**WELWYN HATFIELD BOROUGH COUNCIL  
EXECUTIVE DIRECTOR - PLANNING, PUBLIC PROTECTION AND GOVERNANCE**

**Application No:** 6/2019/1297/LAWP  
**Location:** Just House Coopers Lane Northaw Potters Bar EN6 4NJ  
**Proposal:** Certificate of lawfulness for an outbuilding  
**Officer:** Ms Lucy Hale

**Recommendation:** Refused

PROPOSED FLOOR PLAN

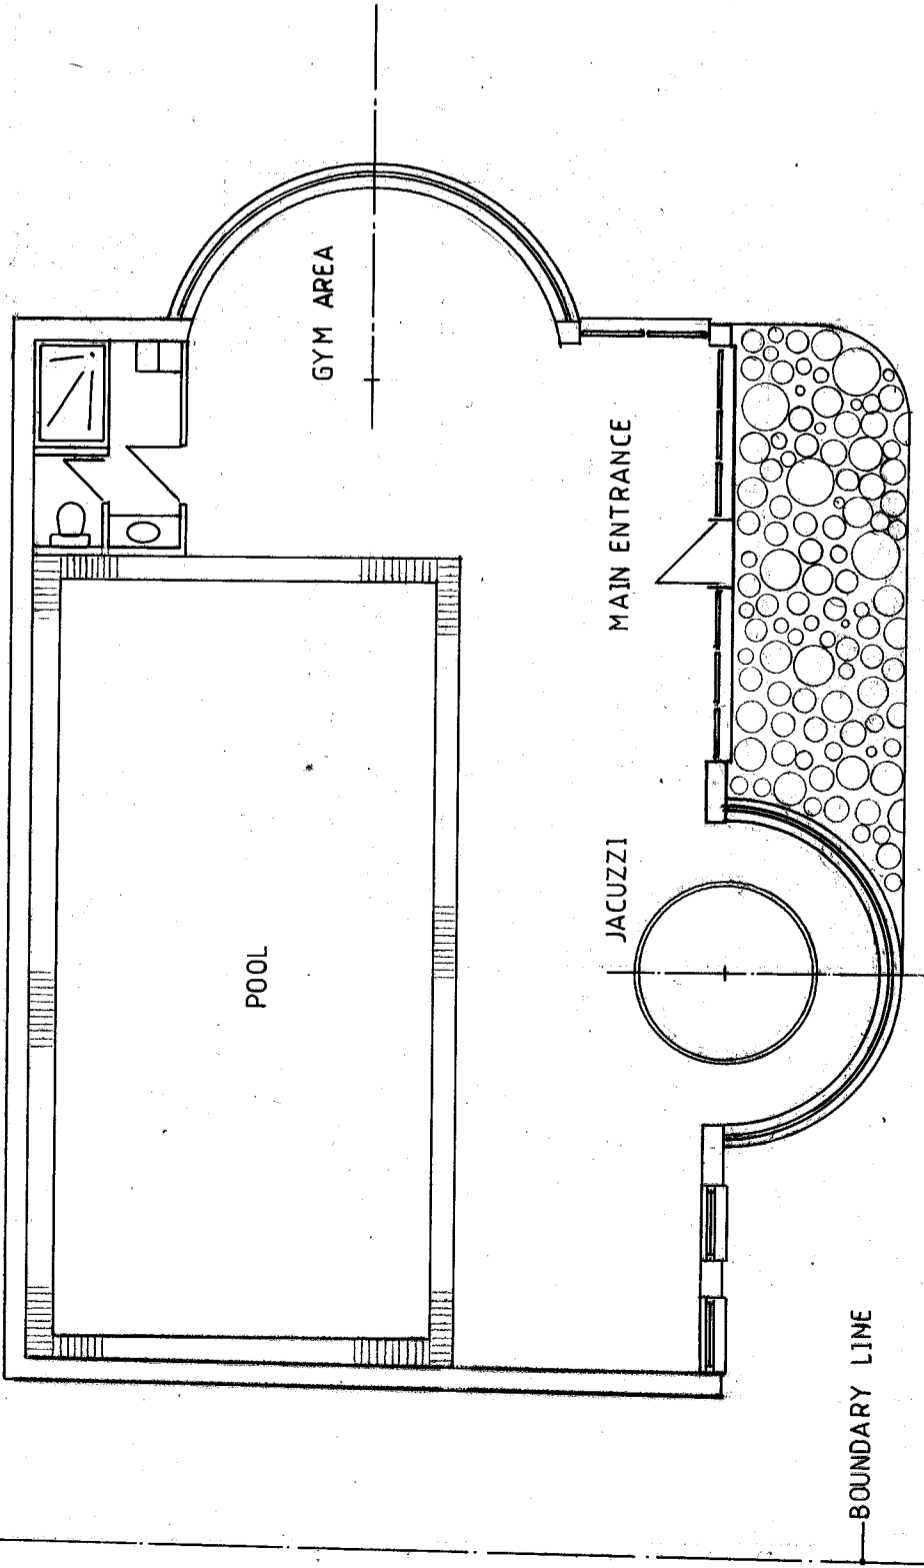
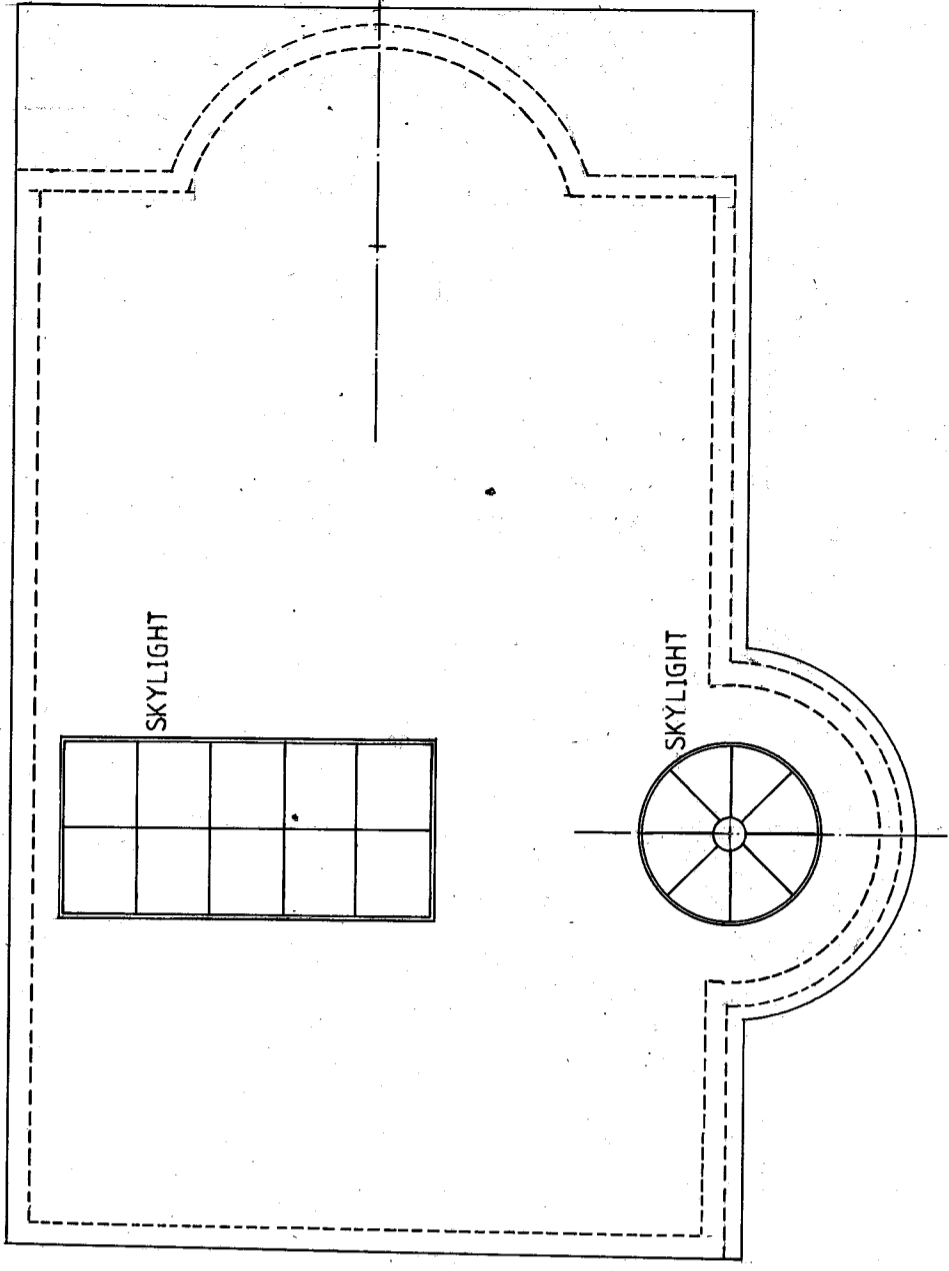
(c) any part of the building, enclosure, pool or container would be situated on land forward of a wall forming the principal elevation of the original dwellinghouse;	Y	N

1. The proposed outbuilding would exceed the limitations of E.1(f) in Schedule 2, Part 1, Class E of the Town and Country Planning General Permitted Development (England) Order 2015 (as amended) by virtue of the height of eaves of the building measuring higher than 2.5 metres.
2. The proposed outbuilding would exceed the limitations of E.1(c) in Schedule 2, Part 1, Class E of the Town and Country Planning General Permitted Development (England) Order 2015 (as amended) by virtue of the outbuilding situated on land forward of a wall forming the principal elevation of the original dwellinghouse.

PROPOSED FRONT ELEVATION

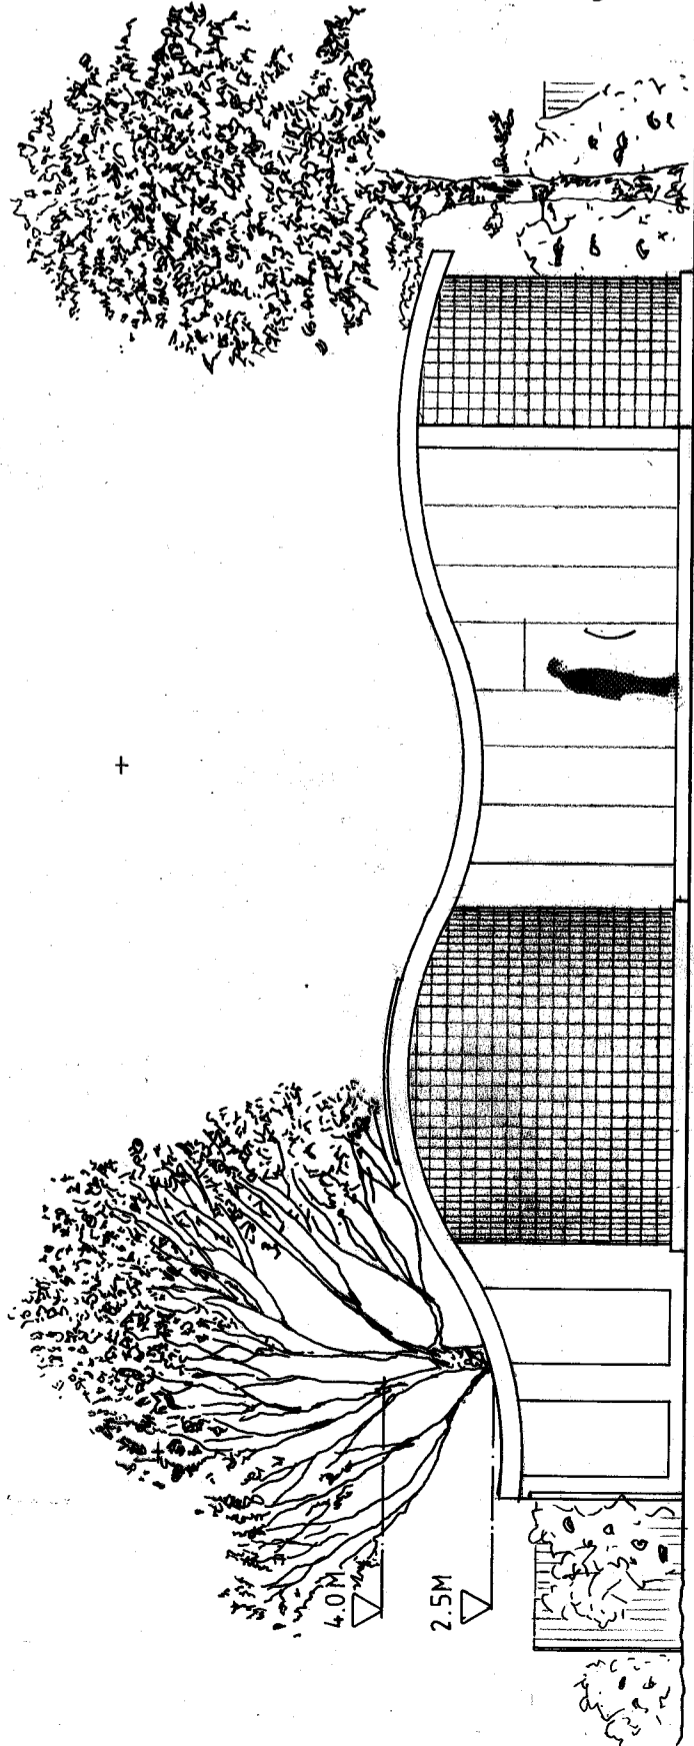
(f) the height of the eaves of the building would exceed 2.5 metres;	Y	N
(g) the building, enclosure, pool or container would be situated within the curtilage of a listed building;	N	N
